**ANGEL PLACE
LEVEL 8, 123 PITT STREET
SYDNEY NSW 2000**

2 June 2022

SECTION 4.55(1A) MODIFICATION APPLICATION | SSD-10375 MOD 1 PITT STREET NORTH OVER STATION DEVELOPMENT

This updated section 4.55(1A) Modification Application has been prepared on behalf of Pitt Street Developer North Pty Ltd (**the Applicant**) to amend SSD-10375 which applies to the Pitt Street North Over Station Development (**PSN OSD**) Stage 2 SSD-10375 at 252 Pitt Street, Sydney.

Proposed Northern Façade [SMCSWSPS-FOS-OSN-AT-DWG-960004 Rev E]

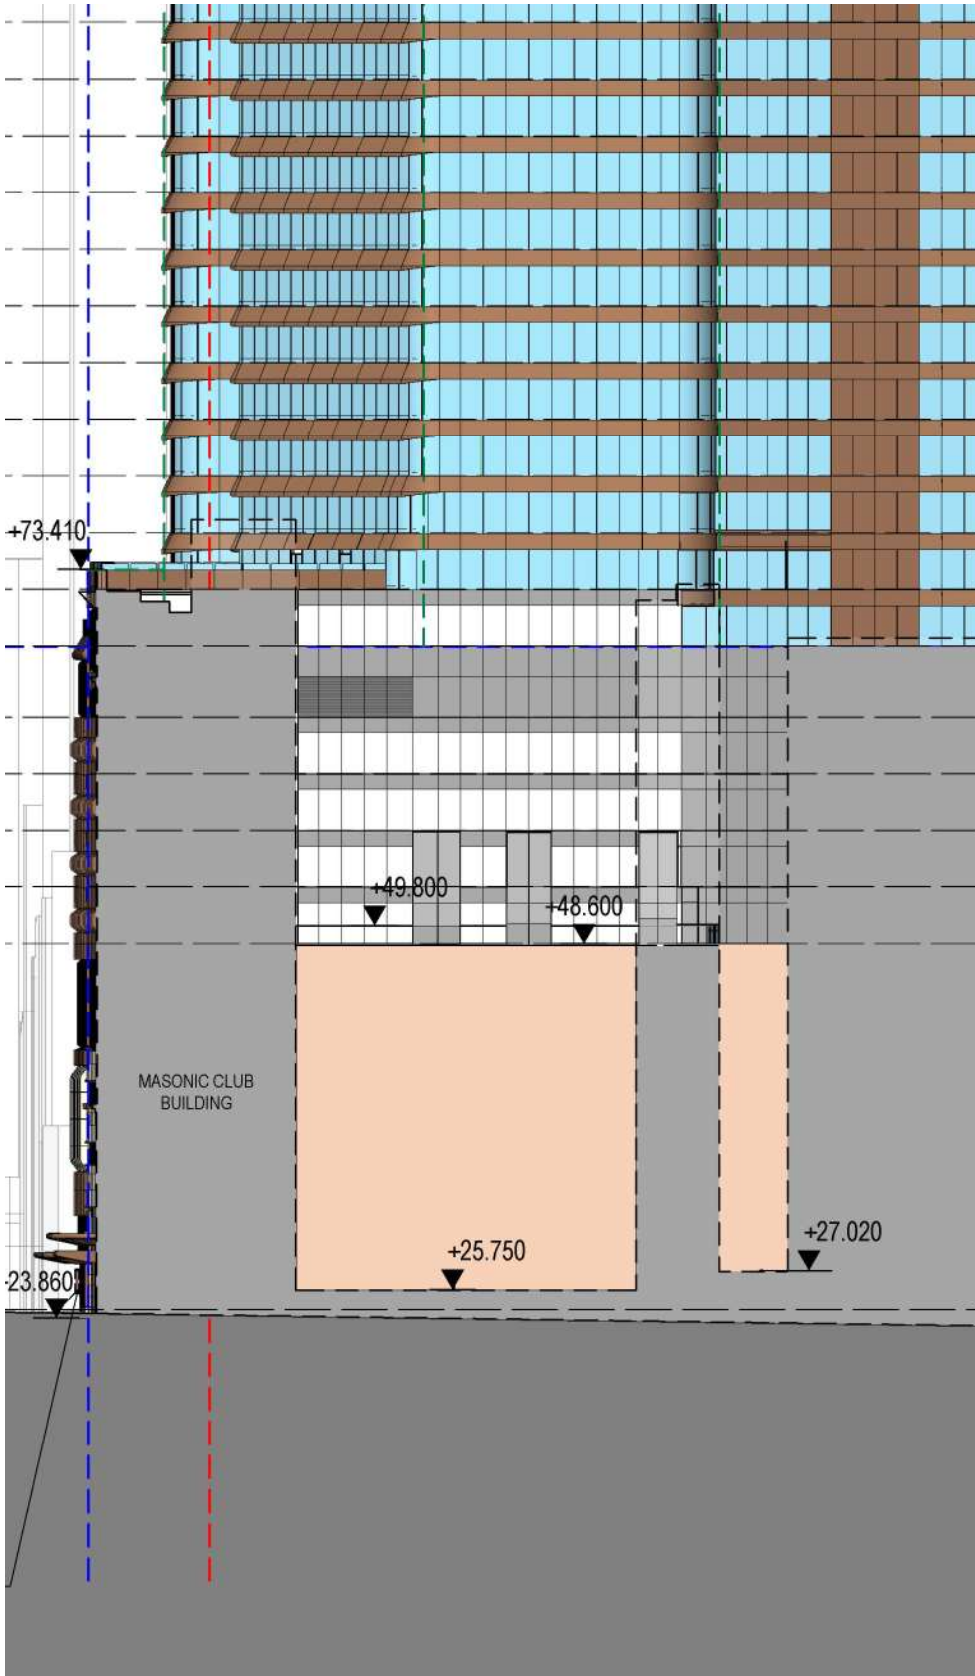
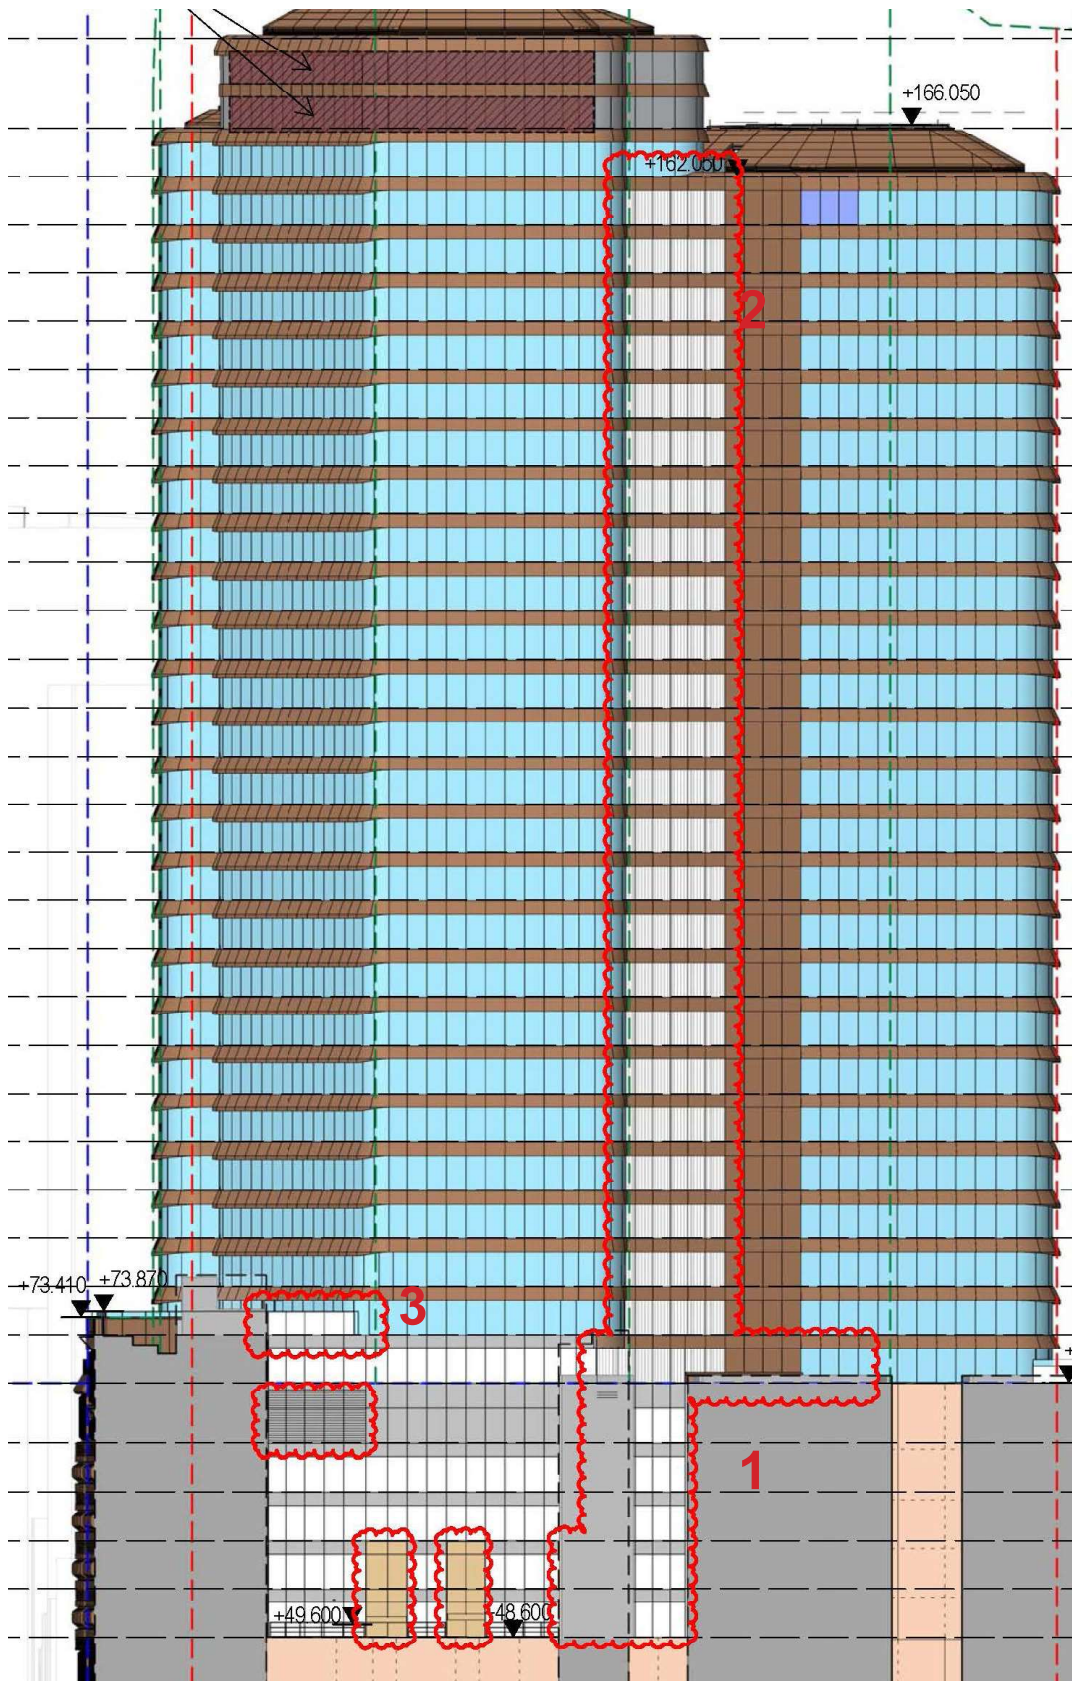
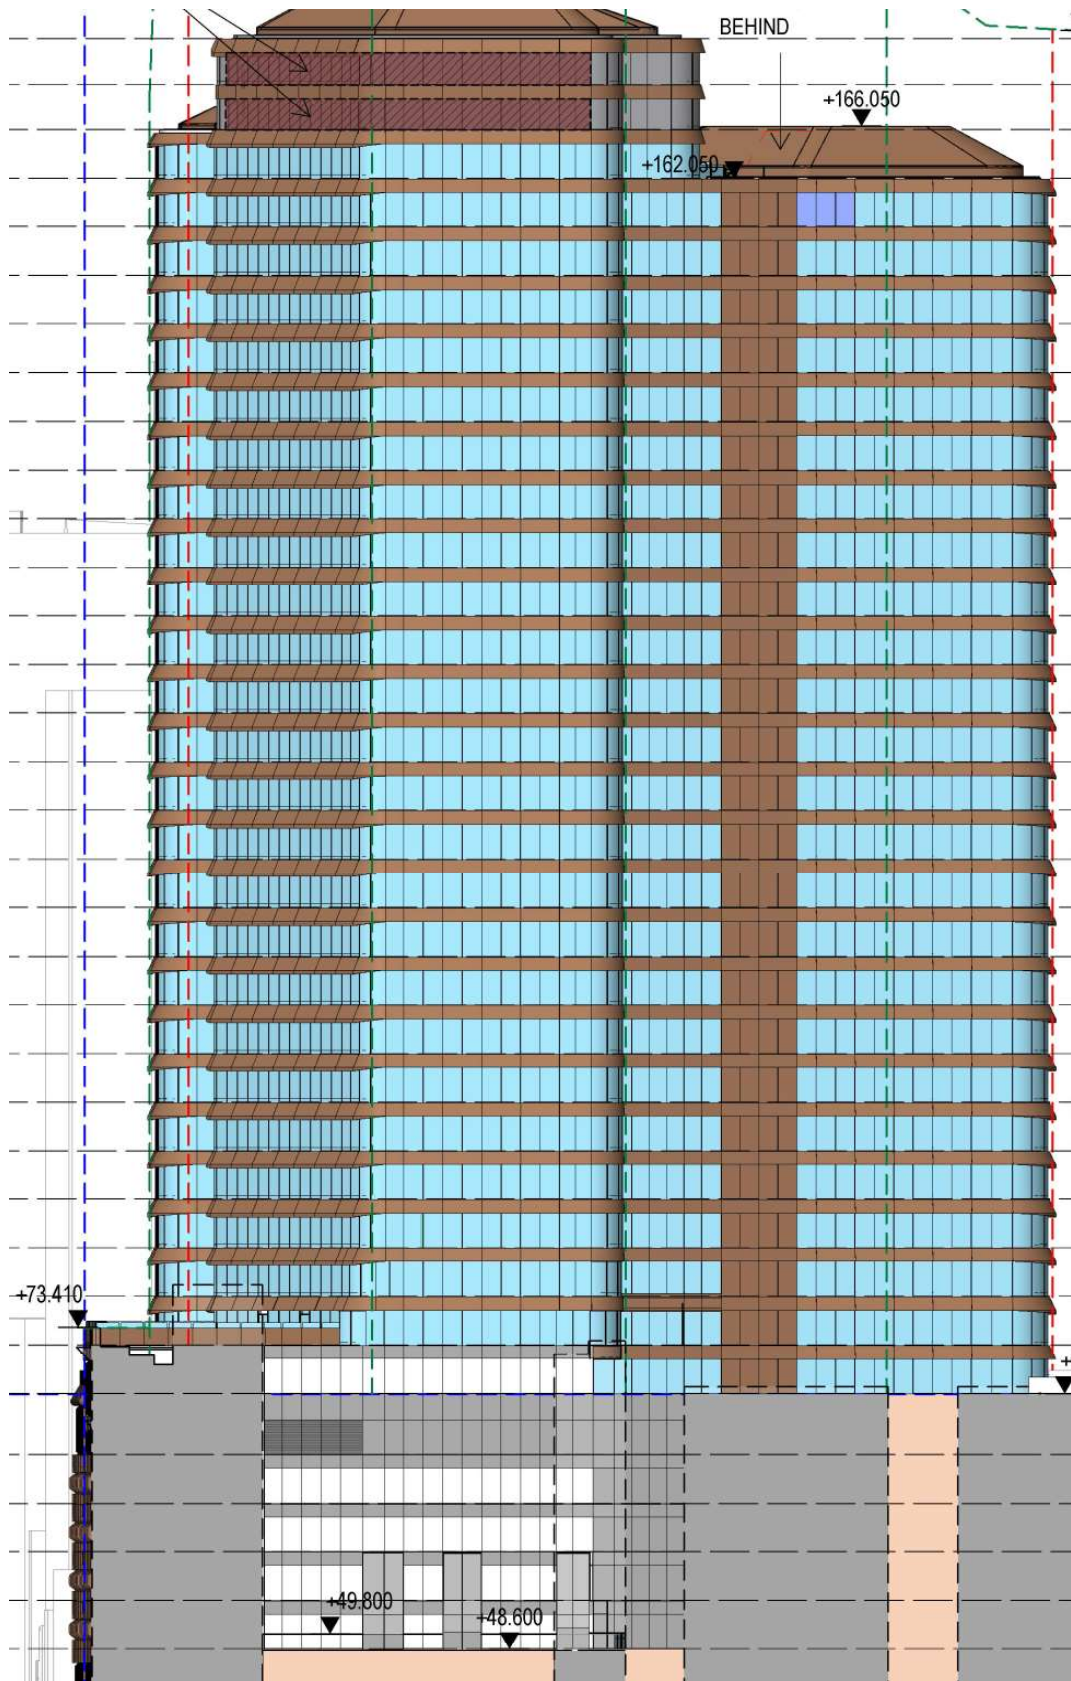
A clarification of the materials on the northern podium façade adjacent to the lightwells of the Masonic Building and Ashington Place is proposed. The white spandrel glazing on the columns has been clarified to be metal cladding and a correction has been made to the colouring on the SSD DA drawings differentiating between translucent curtain wall and white spandrel glazing.

- an update to the level 11 terrace balustrade to a continuation of the translucent glazing below;
- a minor increase in the extent of the mechanical intake/ exhaust louvres; and
- clarification that the glazing adjacent to the amenities is fluted glazing as opposed to a glass curtain wall as noted on the SSD DA approval plans.

Proposed East Elevation [SMCSWSPS-FOS-OSN-AT-DWG-960003 Rev E]

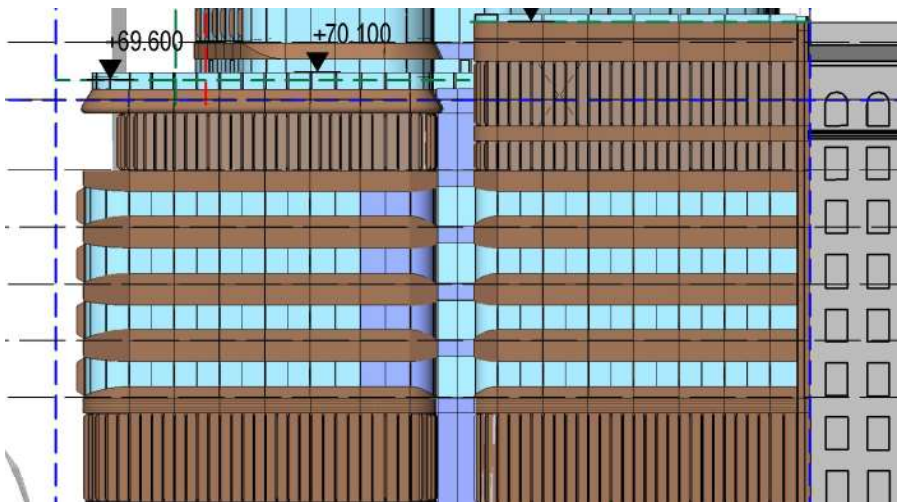
A correction has been made to the podium façade (level 5 through to level 9) on the eastern and western elevations to accurately show the corrugation detailing. This change is a graphical fix as illustrated in **Figure 7** and **Figure 8**.

Proposed: South Elevation [SMCSWSPS-FOS-OSN-AT-DWG-960002 Rev E]

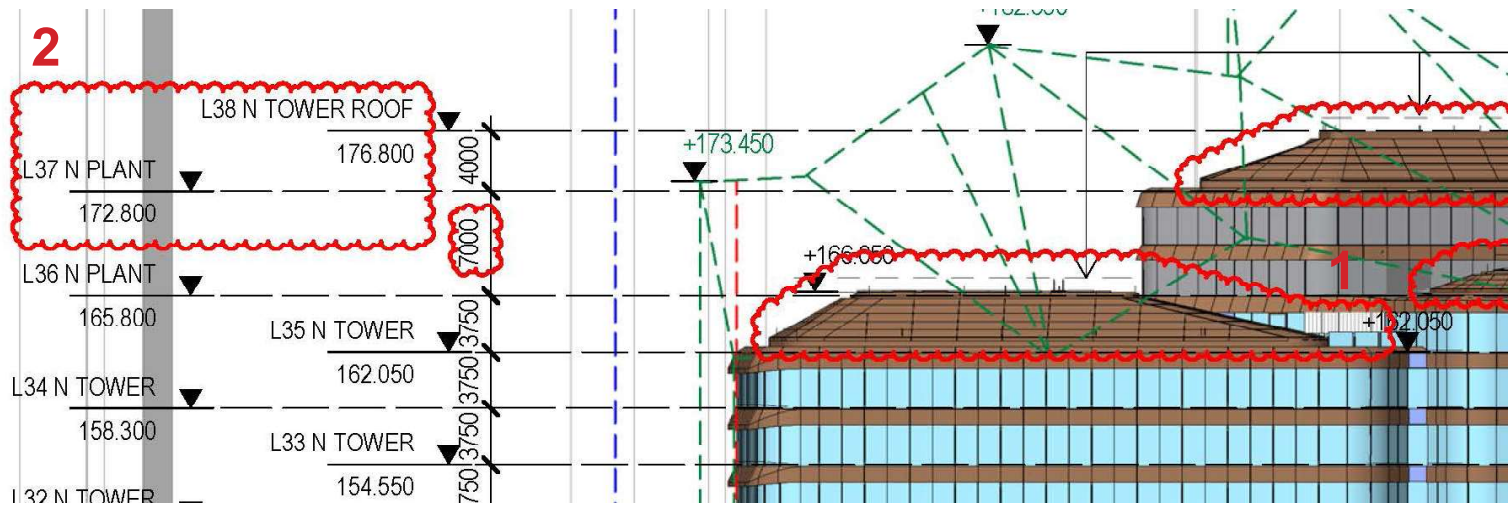
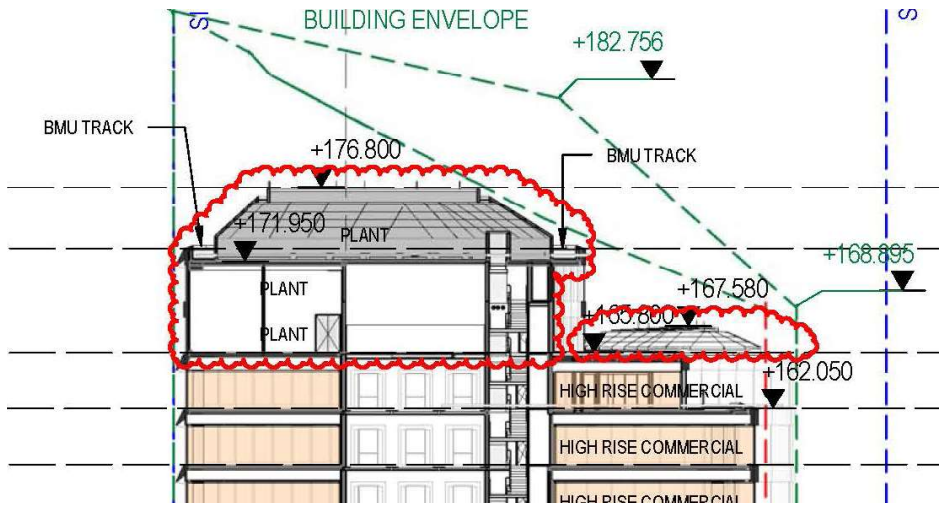
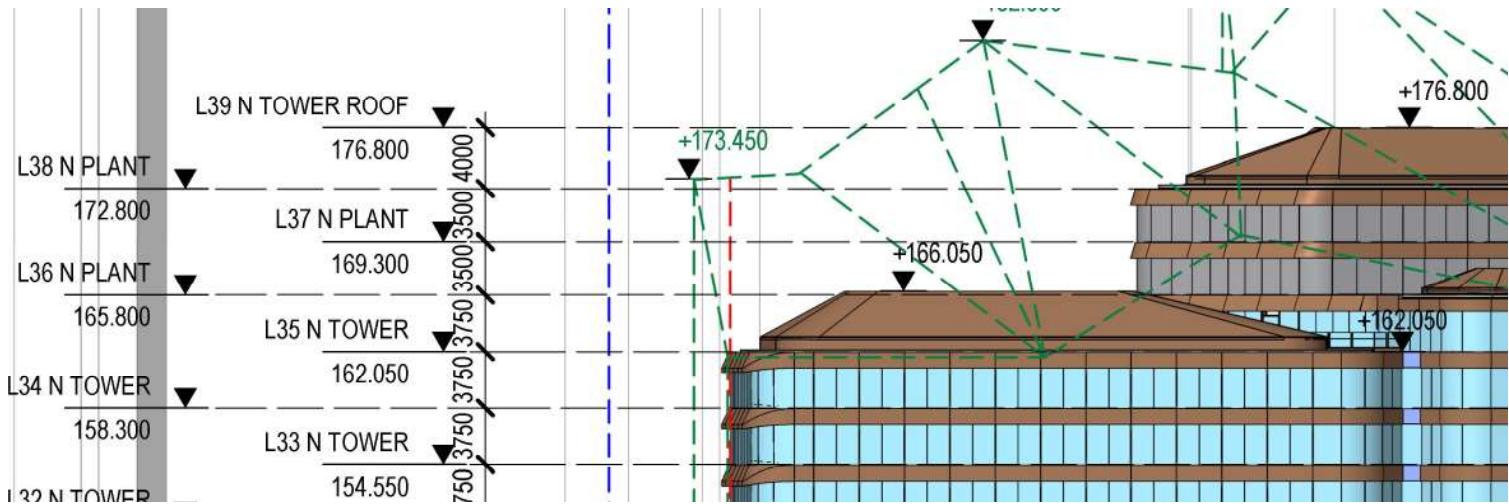
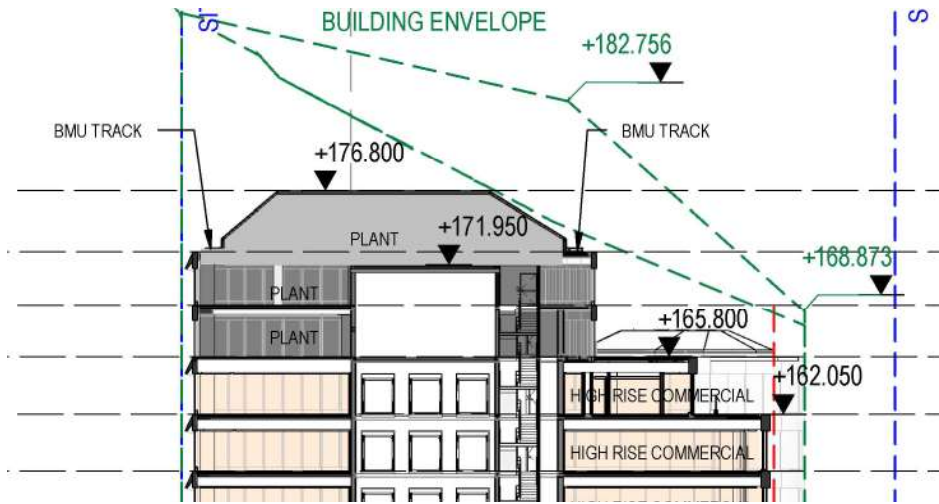
A correction has been made to the south western tower façade (level 35) to show fluted glazing adjacent to the amenities. A correction has also been made to the south western roof detailing, this change is a graphical fix as illustrated in **Figure 9**.

The Level 37 slab and plant rooms (detailed in SMCSWSPS-FOS-OSN-AT-DWG-933713) are proposed to be removed rendering this drawing sheet redundant. As illustrated in Section B-B in **Figure 16** this change results in a double level void but no external changes to the façade or height of the building.
